**Consultation Response from KC,  
Trees**

**2025/93438 Arena Young Peoples Centre, Moorlands Road, Dewsbury, WF13 2LF**

**Erection of 10-unit (class C2) special needs care home, day centre (class E(f), administration and training building (class E(g)(i)**

**Date Responded: 20/01/2026**

Heras tree protection fencing

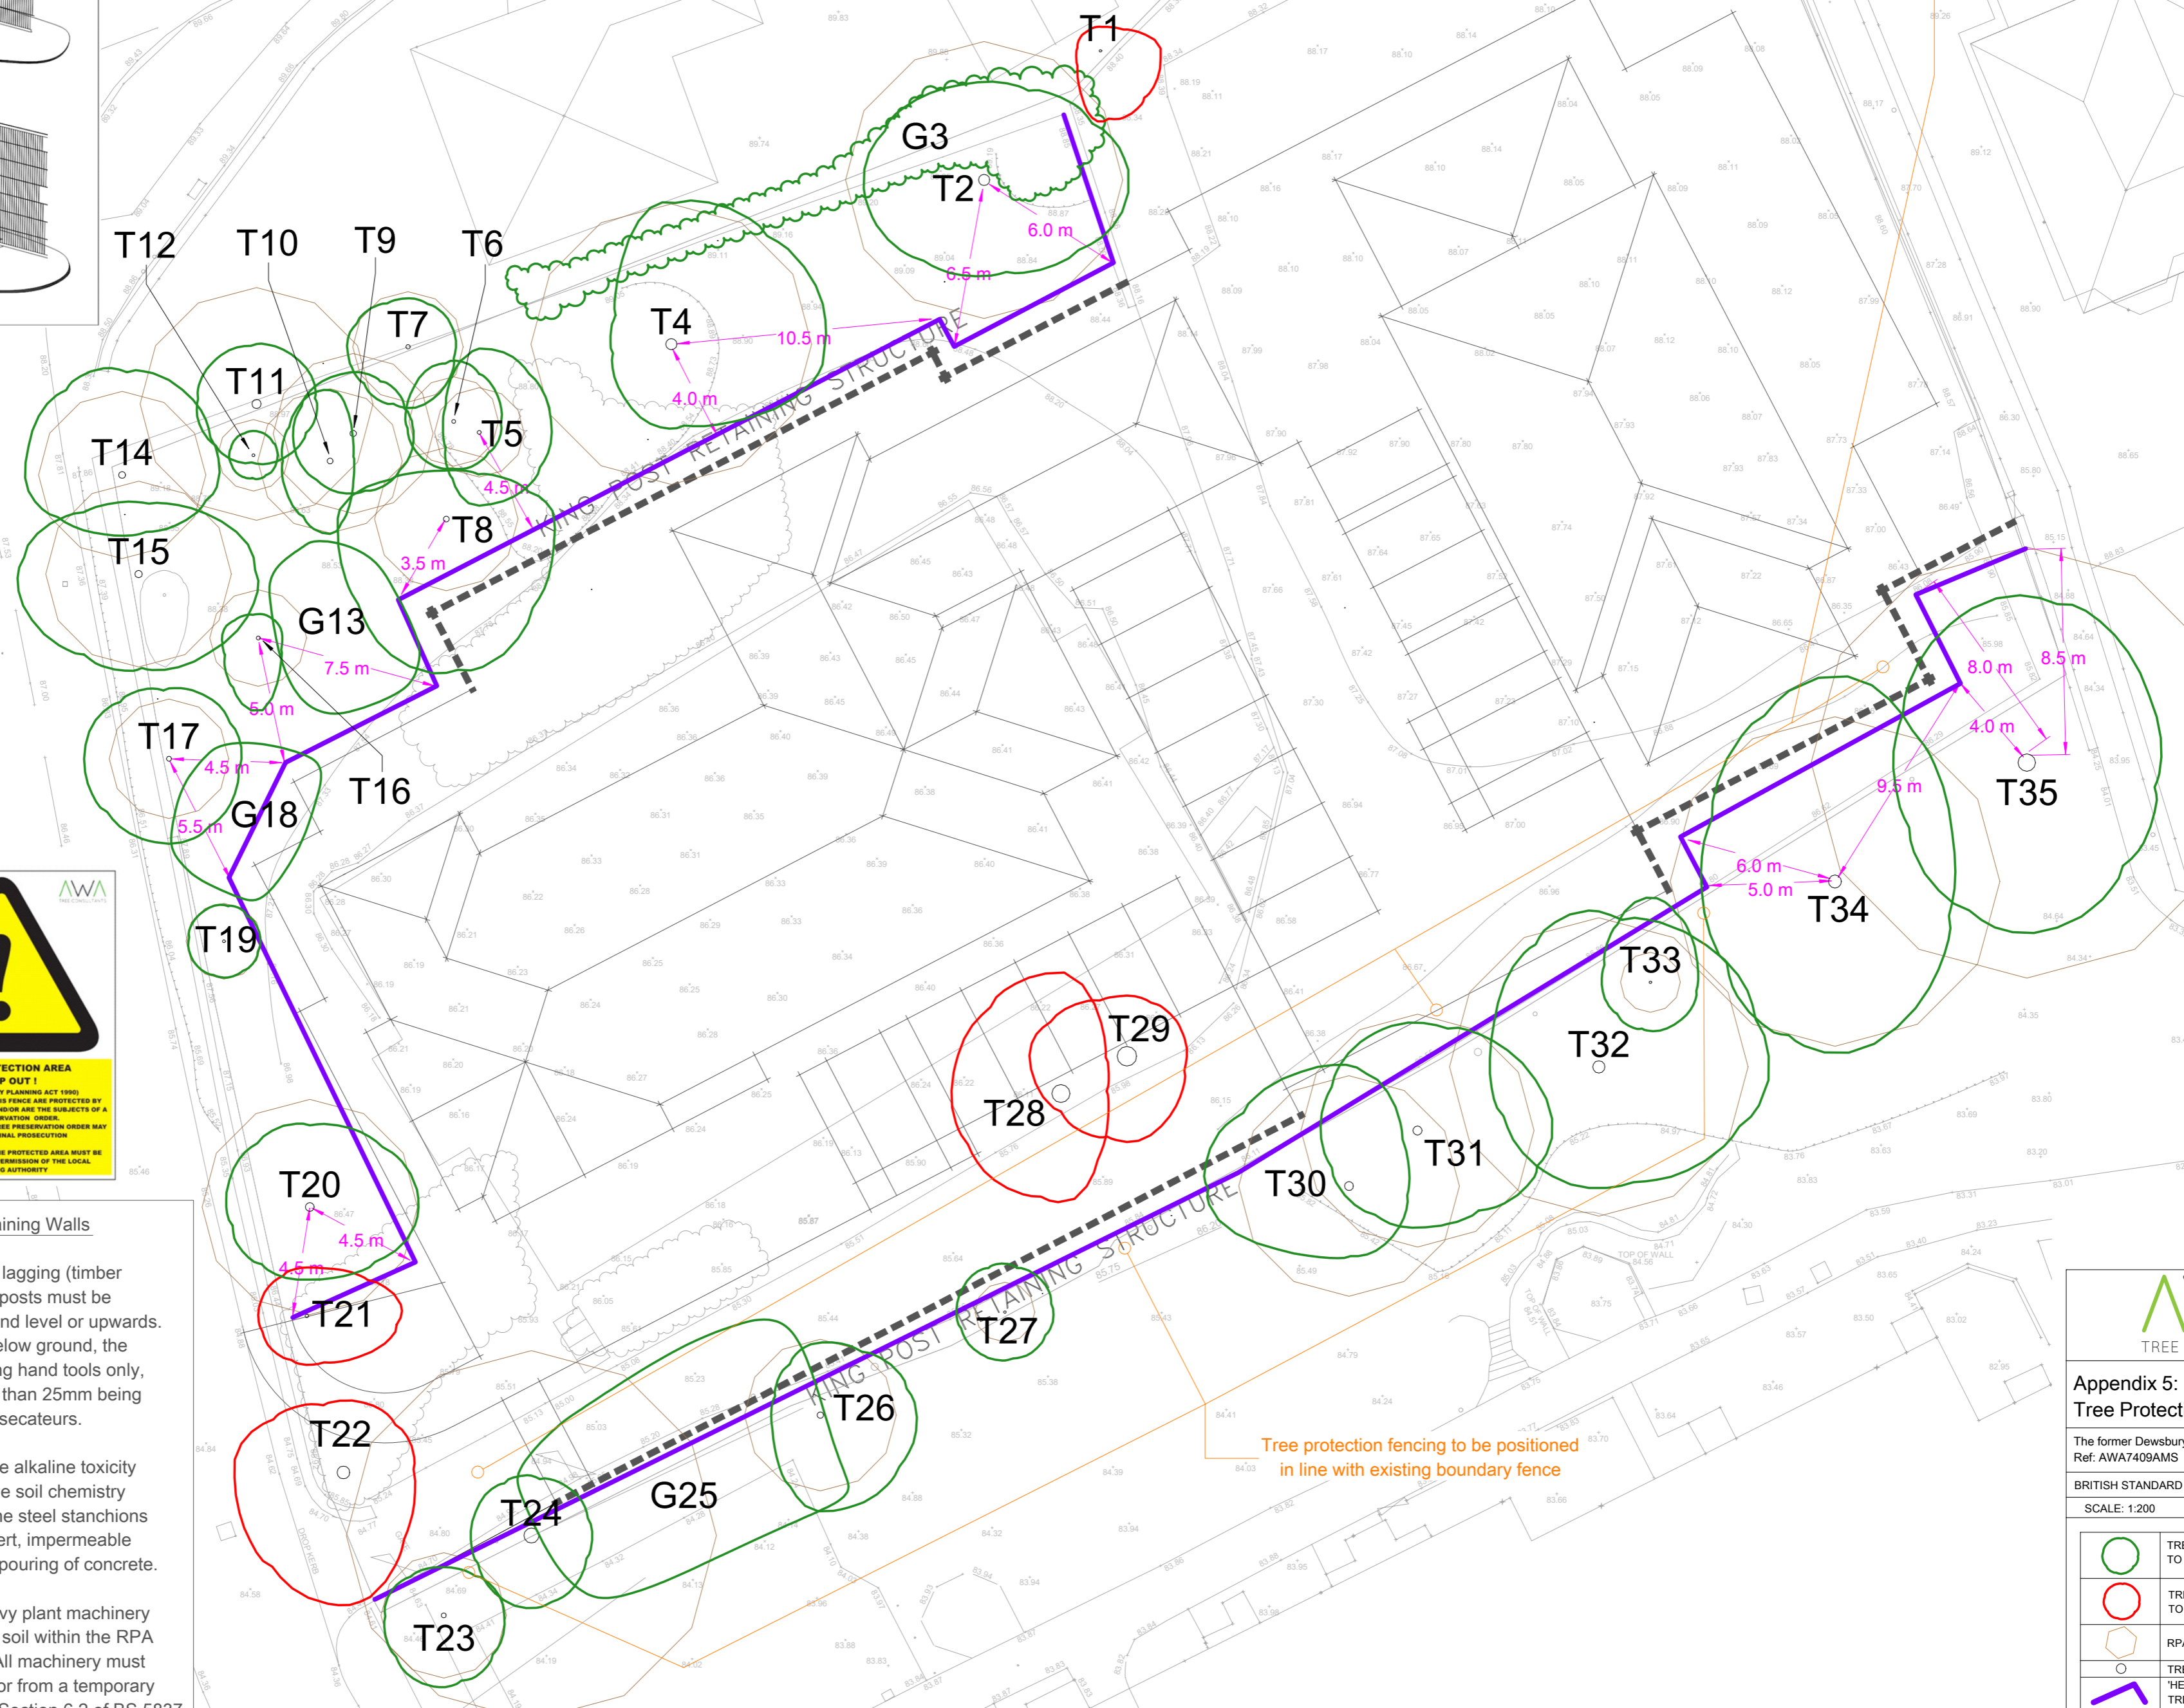
The proposals would require removal/damage to trees, including offsite trees. The construction of proposed structures would cause damage trees: G1, T1, T2, T6, T7, T8 (offsite), T9 (offsite), T13, T14 and T15 (offsite).

BS5837: 2012 s.5 (Proposals: conception and design) includes the requirement to consider the ultimate size of trees. To allow for this, layouts may require careful adjustment to ensure structures are set back sufficiently far enough from retained trees to avoid creating unreasonable inconvenience to future occupiers. A poor relationship will inevitably lead to future pressure on the trees for pruning and felling (with the associated financial cost). Design proposals should avoid the need for frequent remedial pruning, with due consideration to the fact that trees can cause apprehension to occupiers as well as seasonal nuisance: trees are naturally growing and shedding organisms.

There is a holding objection from an arboricultural perspective whilst we await the required arboricultural information in line with BS5837:2012. The proposals conflict with the adopted NPPF and Local Plan policies LP33 and LP24i:
